Your ref: SSD7507

29 August 2016

**Re: Sydney Church of England Grammar School (Shore)
Physical Education Centre (SSD7507)
Blue & William Streets and Hunter Crescent, North Sydney**

LEVEL 1 - STREET ENTRY
PROPOSED DROP OFF & PICK UP

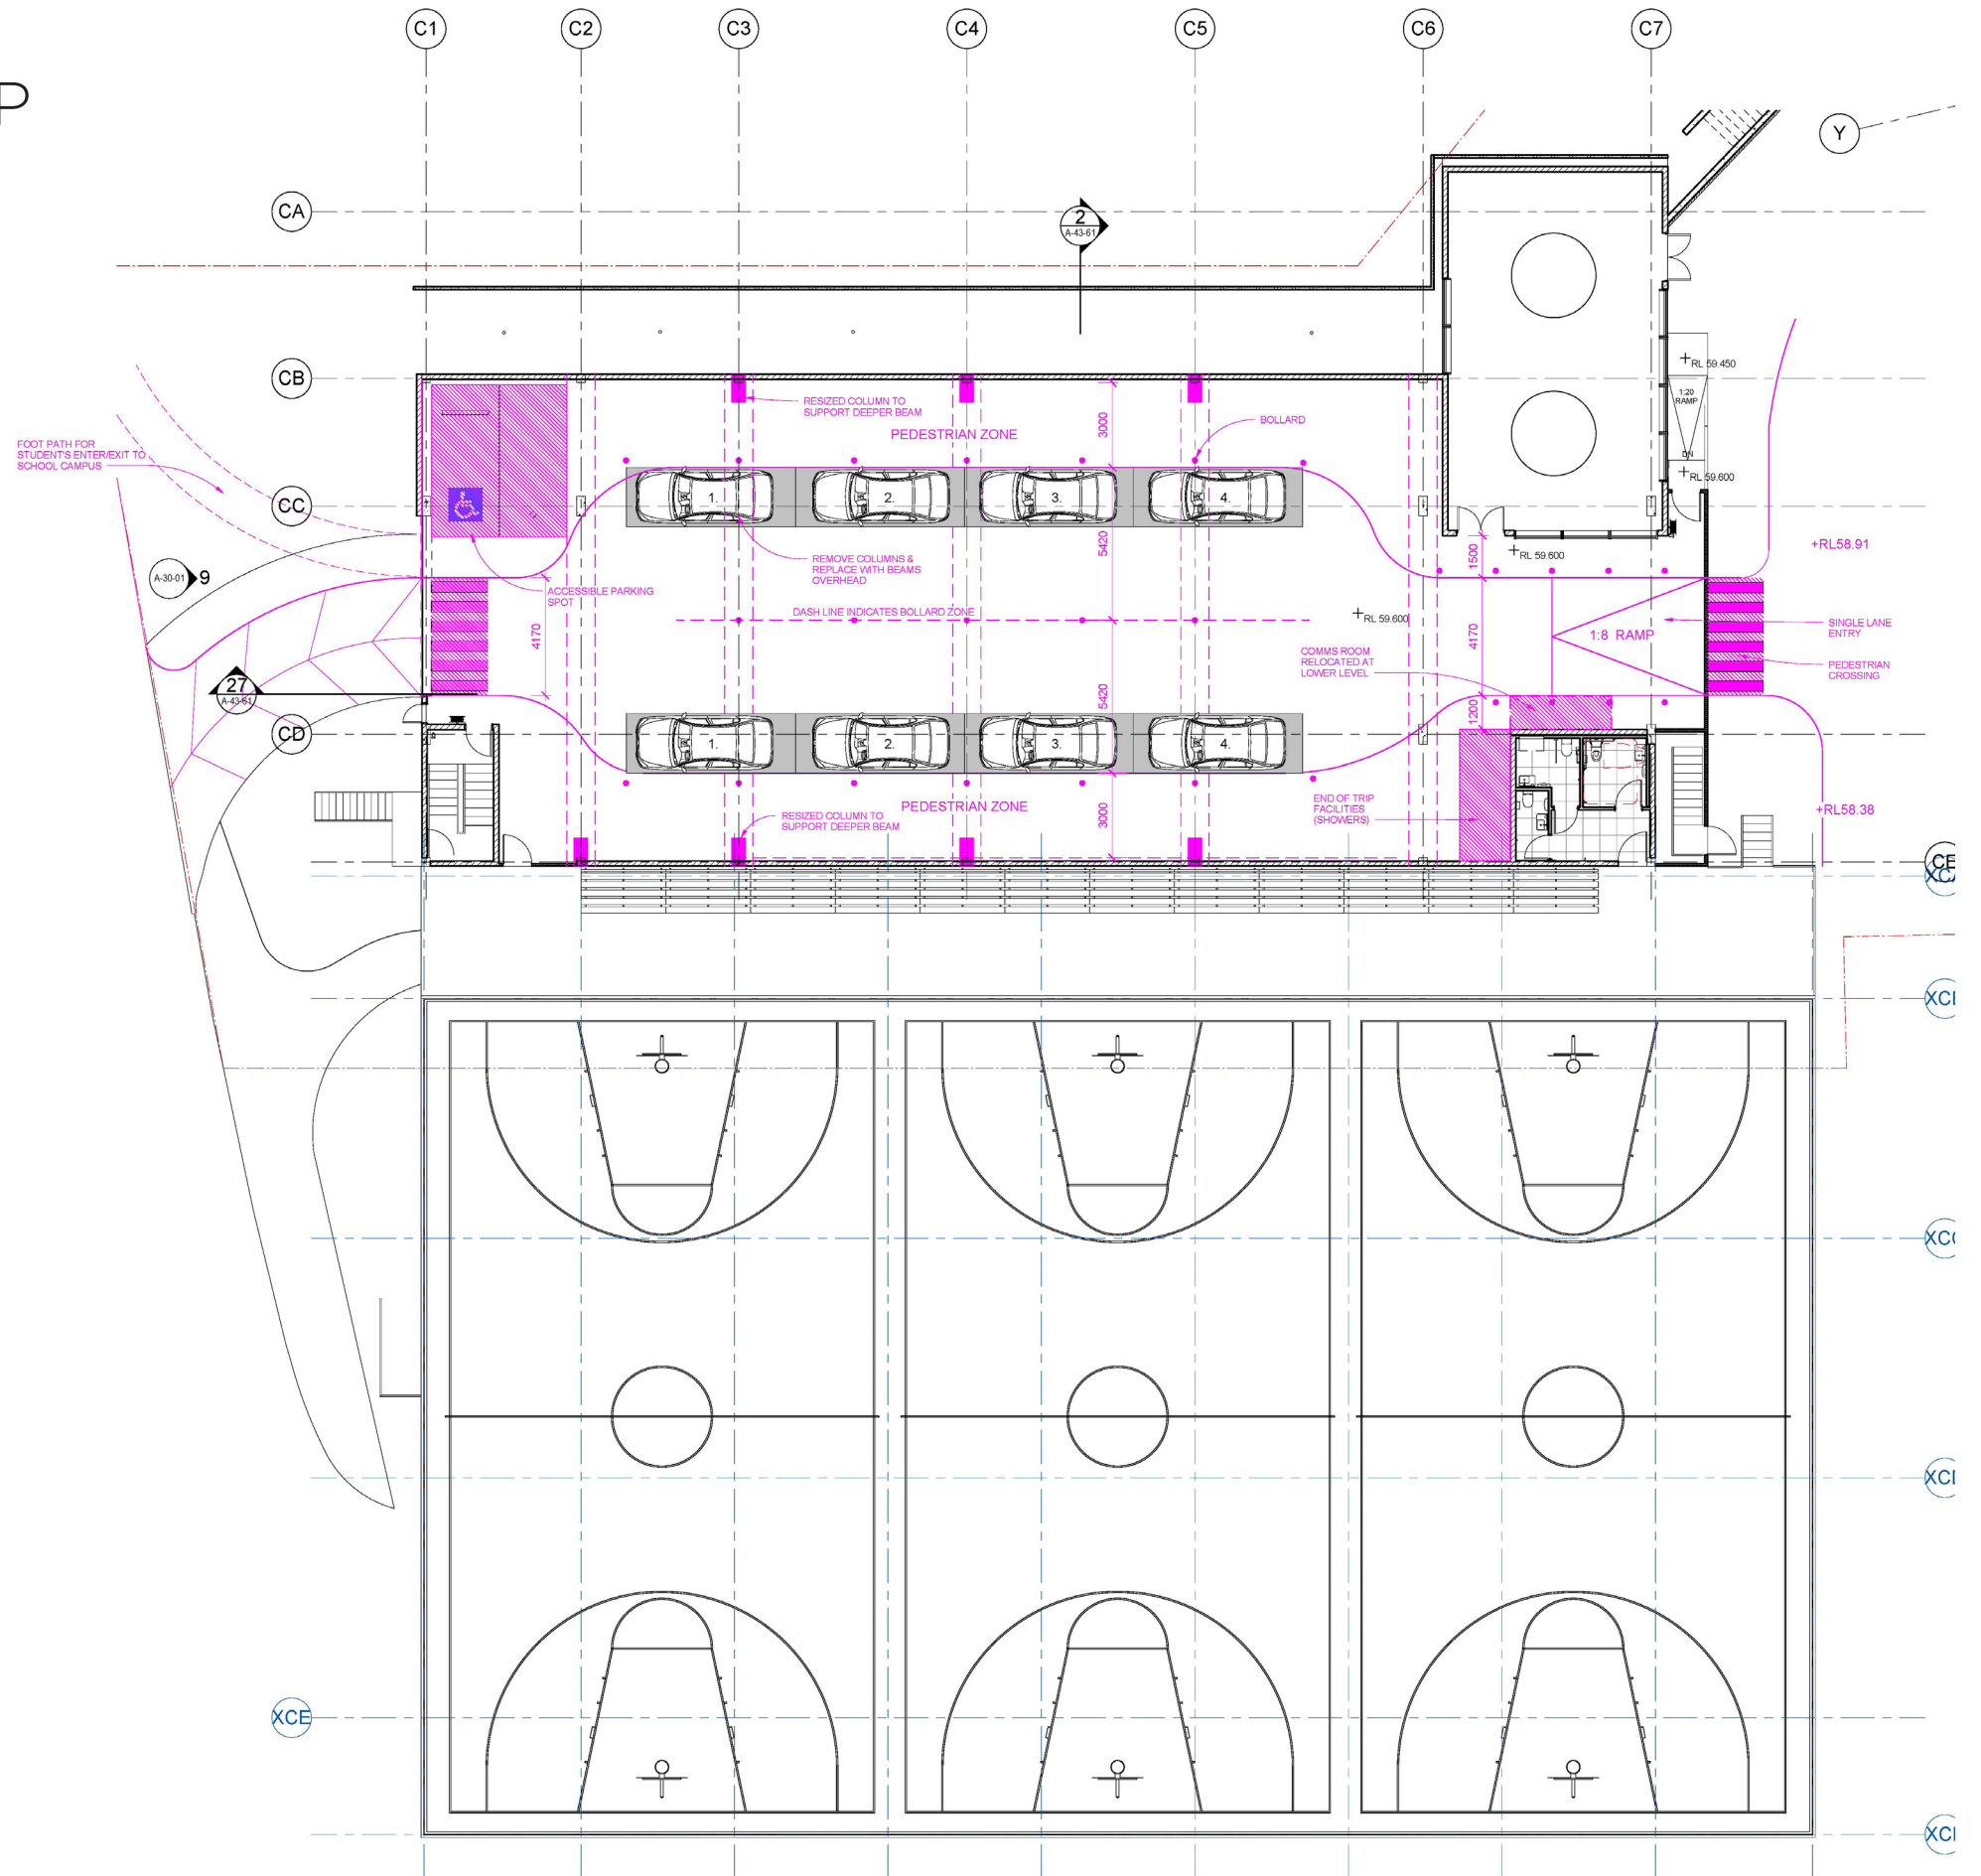
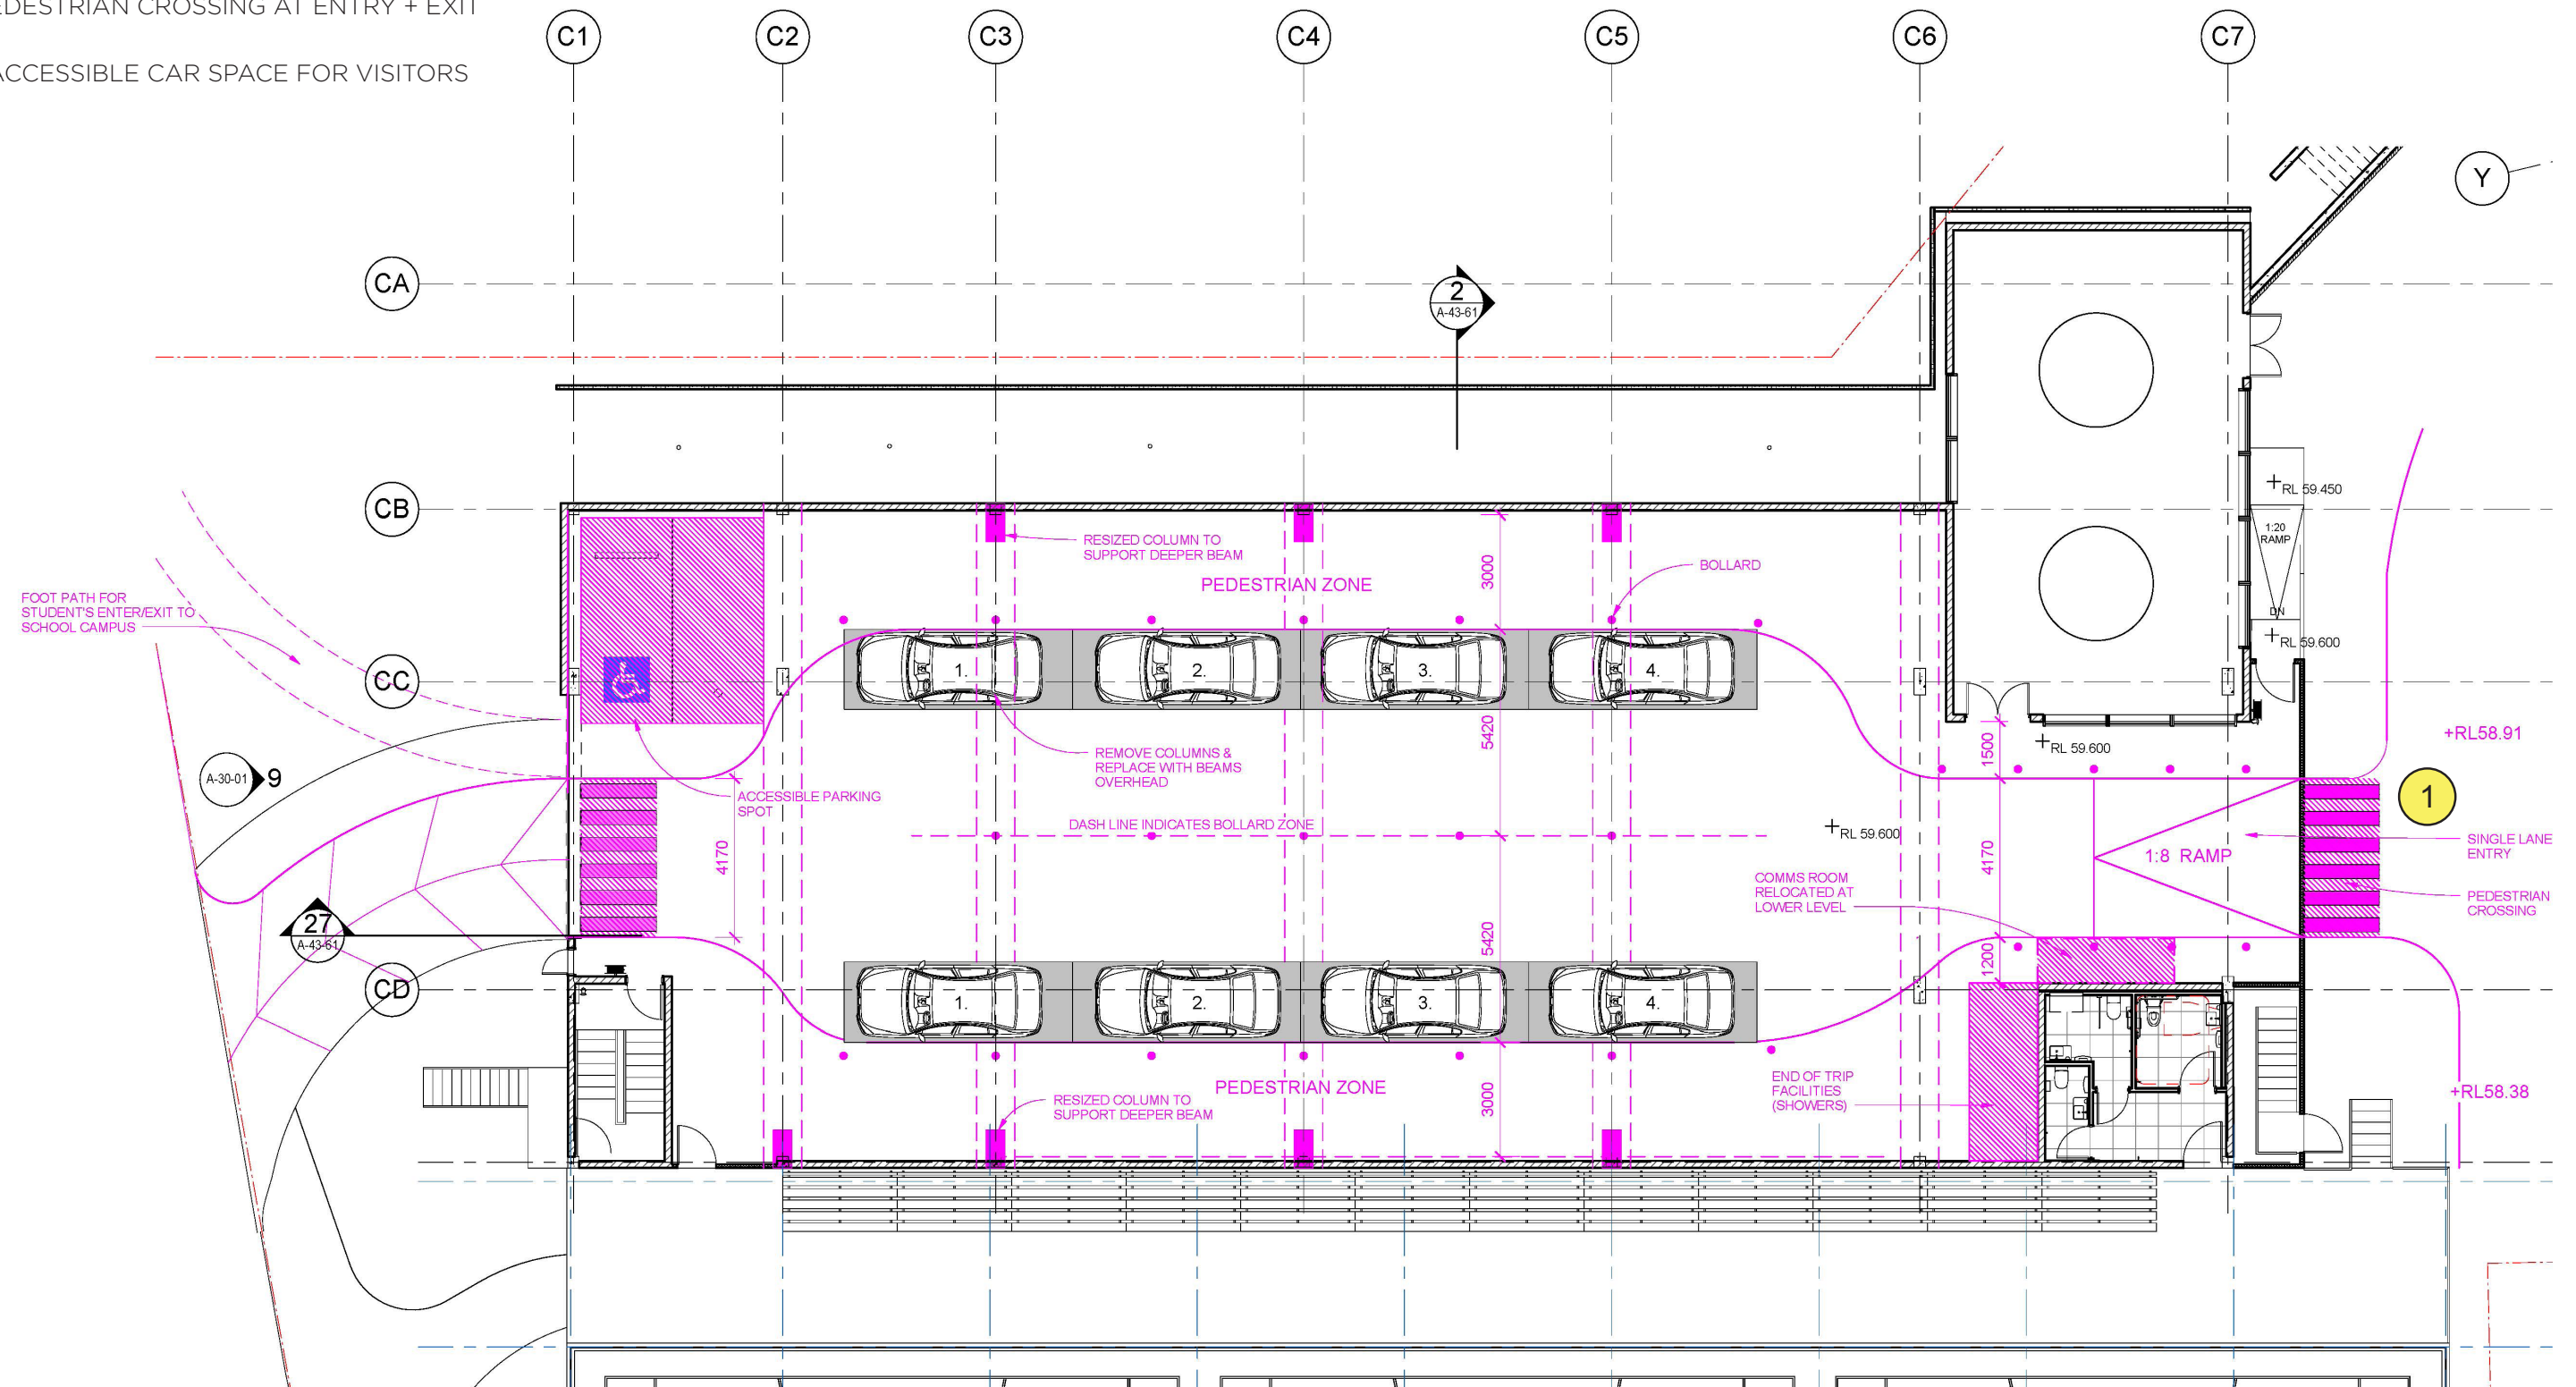
The Traffic Report does not assess the operation of the existing pick-up and drop-off facility. Inspections by Council staff have found that vehicles queue significantly onto Union Street during the afternoon pick-up. The internal pick-up queue exceeded the capacity with up to 9 vehicles queuing on Union Street. There are serious safety concerns with these operations as the queue blocks eastbound traffic on Union Street. East-bound vehicles were forced to overtake the queue of 9 vehicles on the wrong side of the road.

This operation should be reviewed as part of the proposed development and plans should include a reconfiguration of the drop-off and pick-up facility to ensure that all queuing occurs on site.
